Application No: AB/50/21/L
Site Address: Old Bank House 1 High Street Arundel BN18 9AD
Description of works: Listed building consent for the replacement of all windows with new timber double glazed sliding box sash windows and the proposed rendering of the South Elevation (front) and the West Elevation (side) with render painted white.

Thank you for your internet representation made on 16th May 2021 which has been recorded as an objection with the comments as follows:

Vertical Section

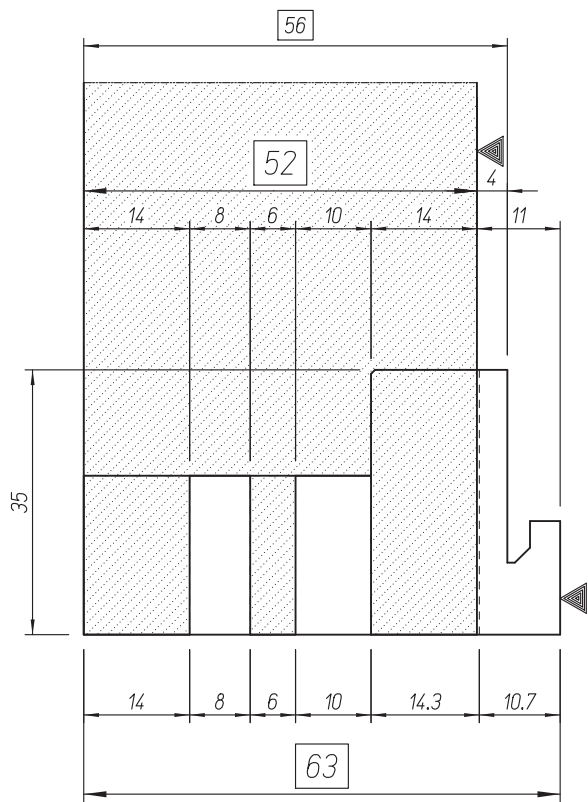
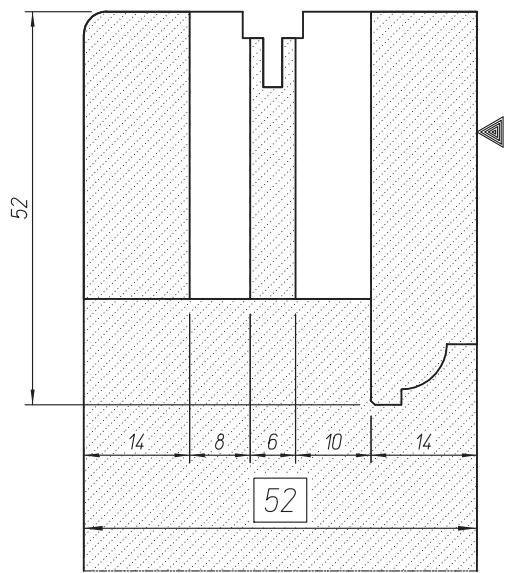
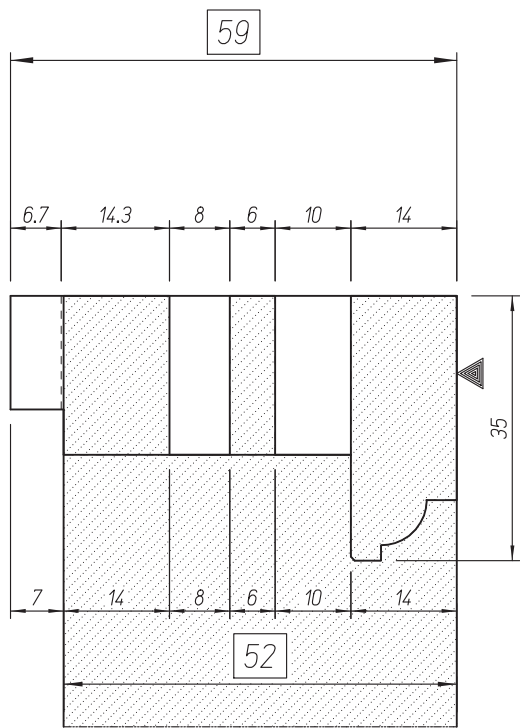
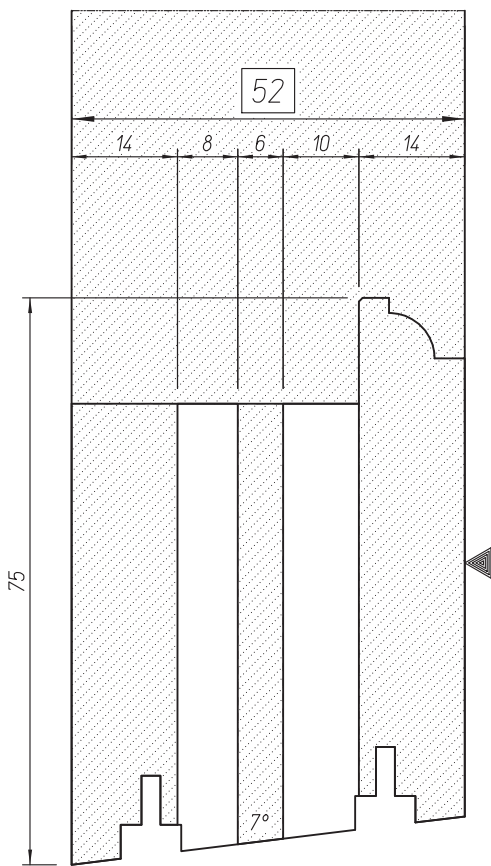
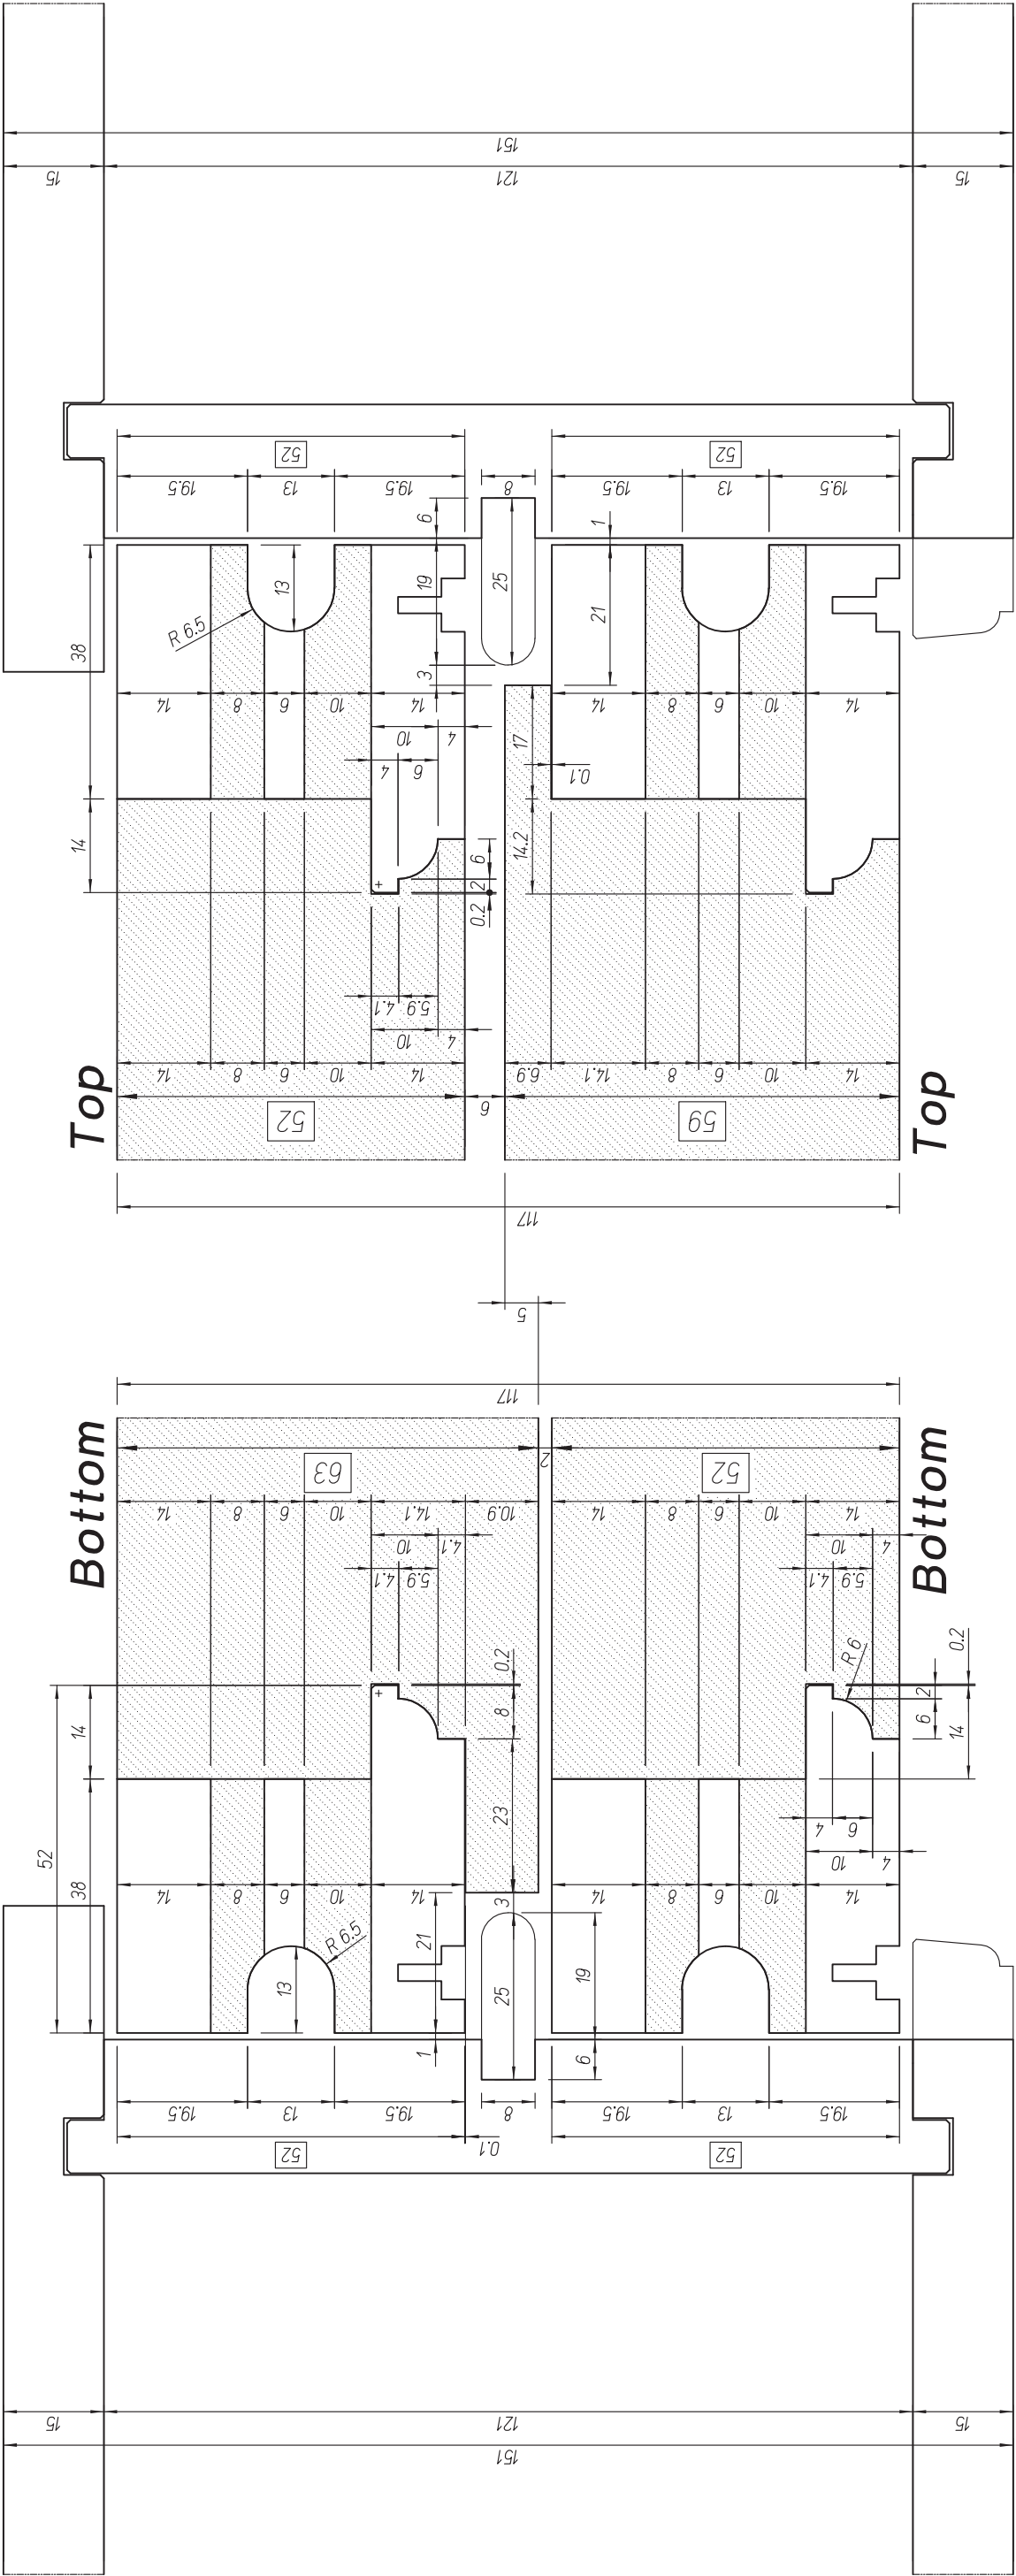
The replacement of this important fenestration with timber double glazed windows with their thicker glazing, dead flat appearance to the glass, and thermal spacers and edging will materially detract from the historical and architectural significance of this listed building. It is difficult to ascertain from the submitted plans how glazing bars, if any, will be treated. It is either intended to use false 'stick on' bars or to use properly formed bars but these would need to be thicker than the originals in order to take the extra weight of the double glazing (this would also likely be the case even with slimline double glazing units). Either detail is simply not appropriate since the existing traditionally constructed slender glazing bars are so important to the character and appearance of the historic building.
